KITTITAS COUNTY COMMUNITY DEVELOPMENT SERVICES

December 22nd, 2017

RE: Swauk Valley Plat (LP-17-00007) – Request for additional information

# RECEIVED CONSERVATION PLAT

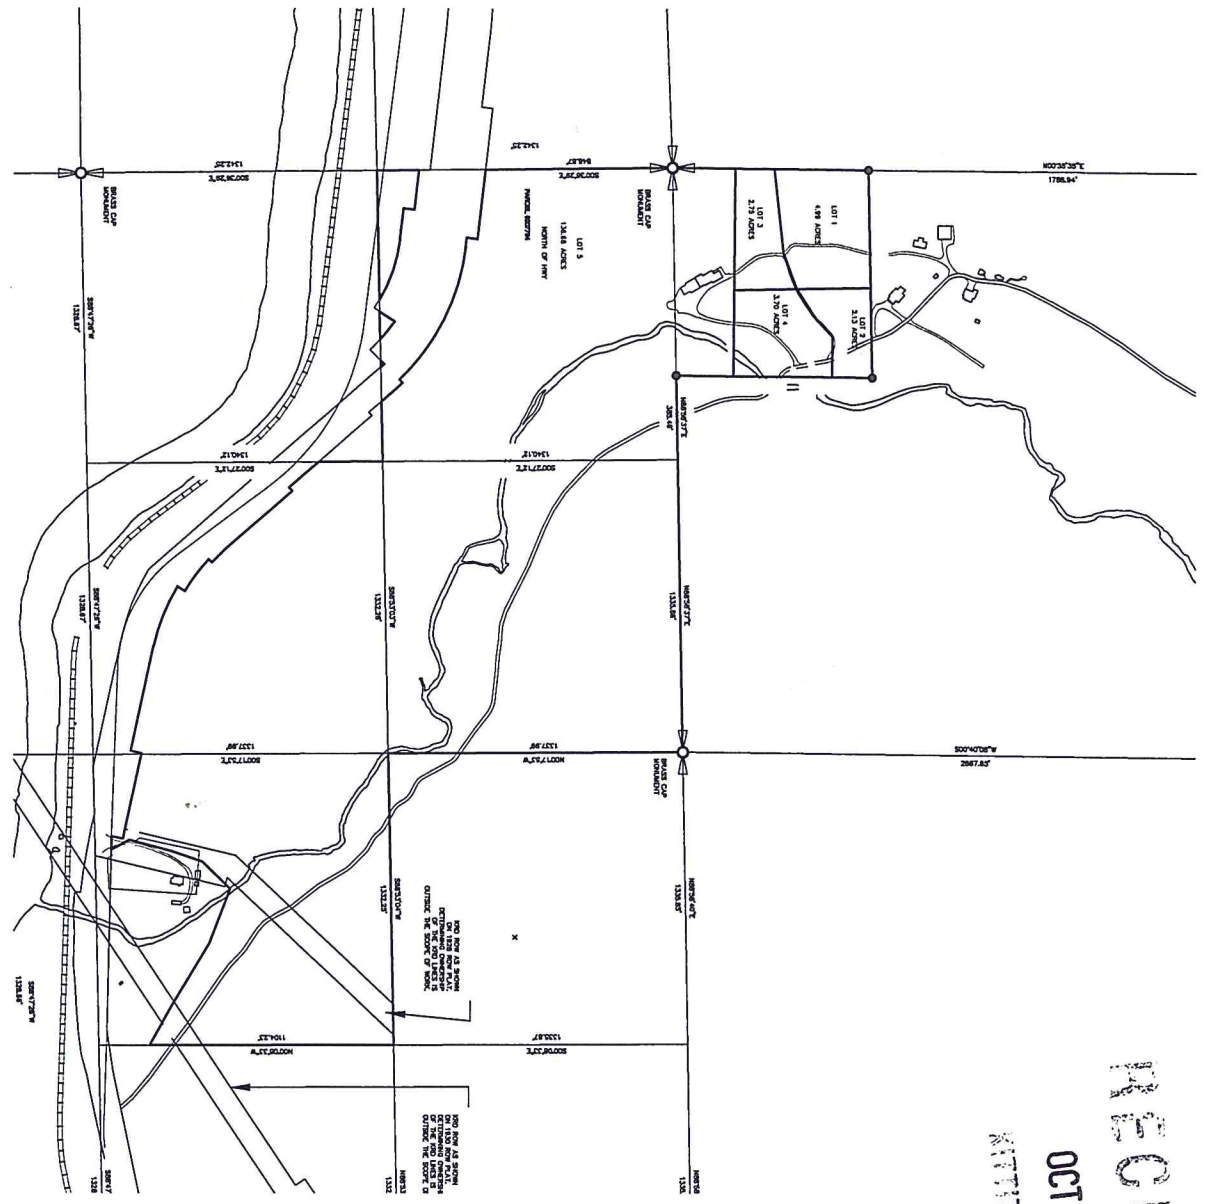
- 1) The farmstead parcel must be adjusted such that it is not larger than 10 acres, in order to meet KCC 16.09.060(2)(a).
- 2) Building envelopes must be shown on the plat, along with a narrative showing justification of location and size of building envelopes, consistent with KCC16.09.060(2)(b).
- 3) A completed SEPA checklist and review fees must be submitted.

As currently proposed, the plat shows a farmstead on a 138.68 acre lot, with four other lots ranging from 2.13 to 4.99 acres, without building envelopes. The plat was submitted as a short plat.
